Our Ref: BE/28/22/NMA

**Section 96A of the Town & Country Planning Act 1990 (as amended)
Town and Country Planning (Development Management Procedure) (England) Order 2015
(as amended) - Article 10**

Non material amendment following BE/135/18/PL for alterations to approved external appearance of Units 6/7 and minor roof amendments.

Units 6/7 Land at Saltbox West of Shripney Road Bognor Regis PO22 9NW

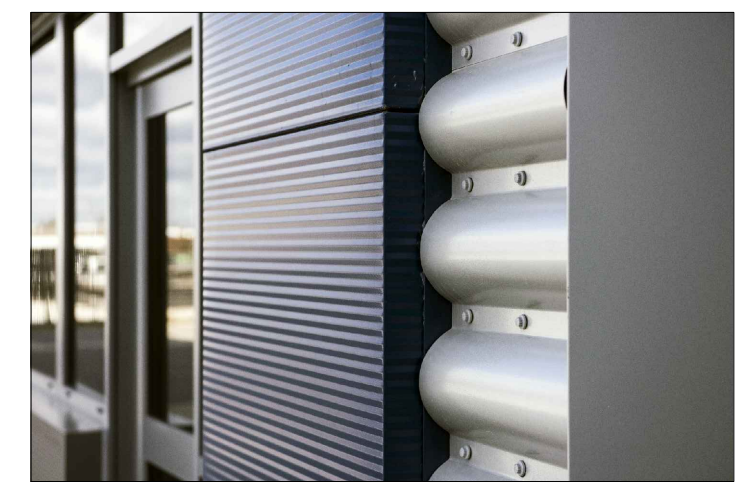
This Non-material amendment application seeks to change the roof to incorporate hip features at the west and east ends of the Unit 6 and 7. In addition to this, there are also proposed changes to the external materials. The units will continue to accommodate the intended 42sqm of Solar PV on the roof as approved under NMA application (BE/125/21/NMA dated 10th August 2021). There are no changes to the site layout scale or dimensions of the approved buildings.

The reason that this proposal has been accepted as a Non-Material Amendment is because it is amending the roof form, and materials of Unit 6-7. The proposal can therefore be considered under Section 96A of the Town and Country Planning Act 1990. As proposed change to a hipped roof and choice of materials would not change the description or conflict with any conditions imposed on the original planning application. The external materials now included:

- Profiled built-up roof cladding in HPS200 Goosewing Grey BS A10A05
- Circular RWPs in Grey Aluminium RAL 9006 or Sargasso Blue RAL 5003 to match adjoining

cladding.

- Gutter fascia in Grey Aluminium RAL 9007
- Horizontally laid profiled built-up wall cladding (half-round or trapezoidal) and related flashings in Metallic Silver colour RAL 9006
- Horizontally laid Microrib composite wall cladding in Sargasso Blue RAL 5003
- Horizontally laid Microrib composite wall cladding in Grey Aluminium RAL 9007
- Coloured insulate loading doors in Grey Aluminium RAL 9007
- Powder coated windows and curtain walling in RAL 9007
- Fire escape doors in RAL 9006 to match cladding
- Glazed spandrel panels
- Turn opening windows
- Unit name panatrim boards

Ian King Associates KP-281-Units 6/7-NMA-01 and KP281-Units 6/7-NMA-02 now form part of the approved planning drawings for BE/135/18/PL at Saltbox in place of:

1744-TU-P04B (Proposed Roof Plan) and 1744-TU-P05C (Proposed Elevations)
